# BUSHKA AG SHORT PLAT LOCATED IN SECTION 2, T. 17 N., R. 19 E., W.M. KITTITAS COUNTY, WASHINGTON

SP-07-68

### RE: Bushka Ag Short Plat (SP-07-68)

The Kittitas County Community Development Services Department has determined that the Bushka Ag Short Plat (SP-07-68) is a complete application and hereby grants **conditional preliminary approval** subject to the following conditions:

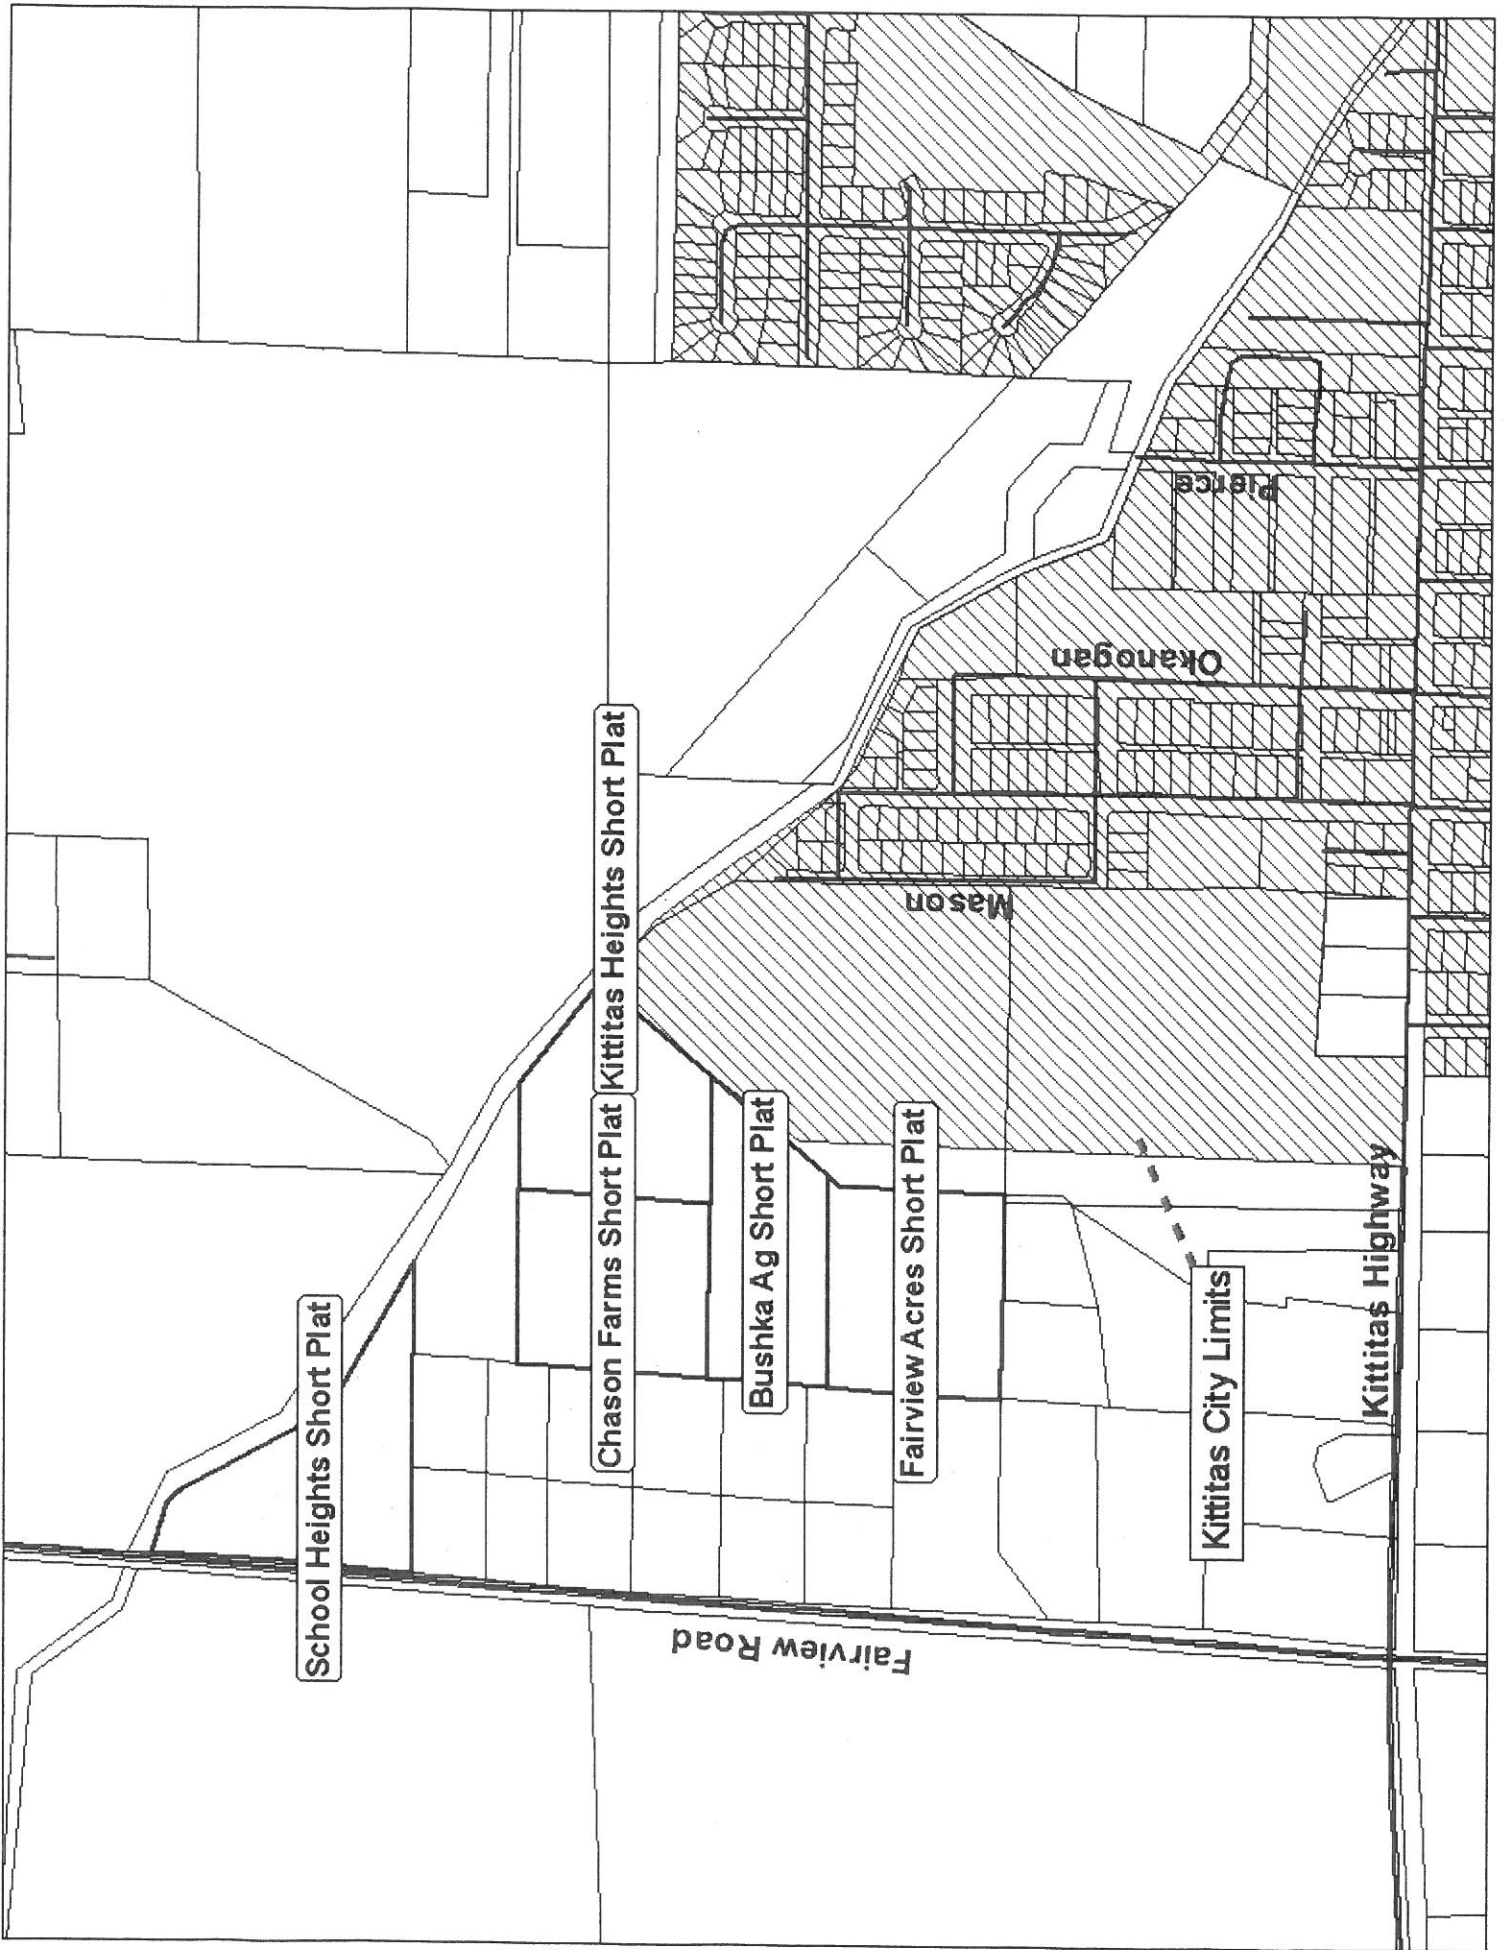
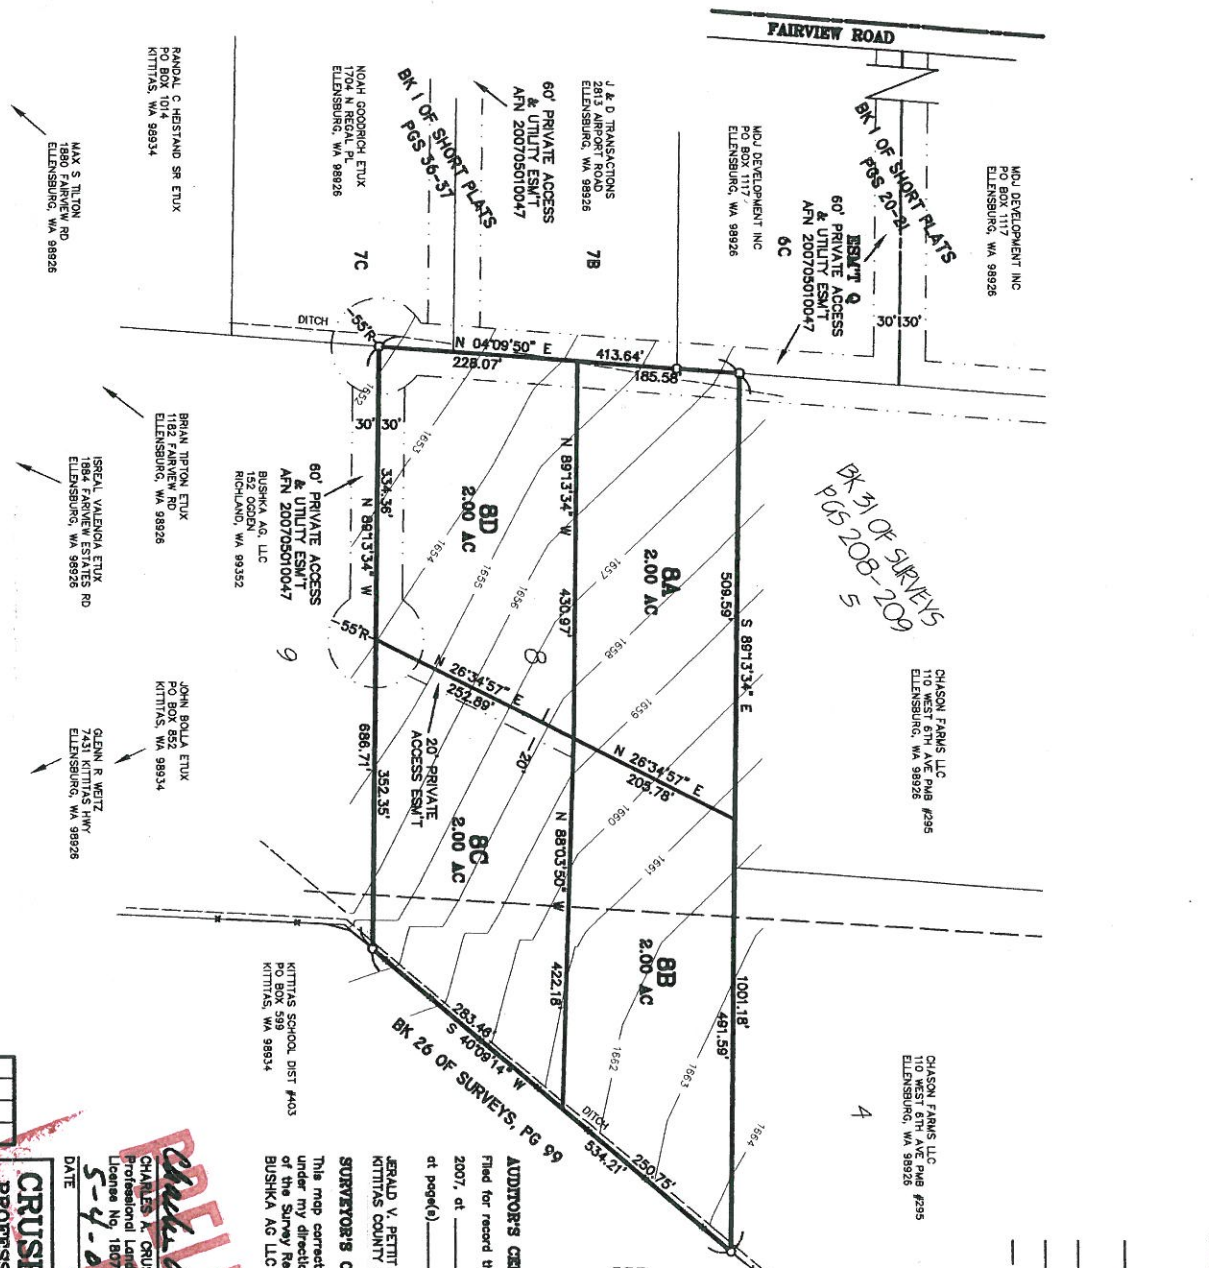
Easement AFN: The easement south of lot 8D was not included in the easement document recorded under AFN 200705010047. The easement appears to be established by this short plat.

Cul-de-Sac: A cul-de-sac turn-around having an outside right-of-way easement diameter of at least 110 feet shall be constructed at the closed end of all dead-end roads serving 3 or more lots. The driving surface shall be at least 96 feet in diameter. Cul-de-sacs must also conform to the requirements specified by the 2006 International Fire Code. Contact the Fire Marshal regarding any additional cul-de-sac requirements.

Lot 8A and 8B Access: Access to Lot 8A and 8B shall be from the 20' private access easement.
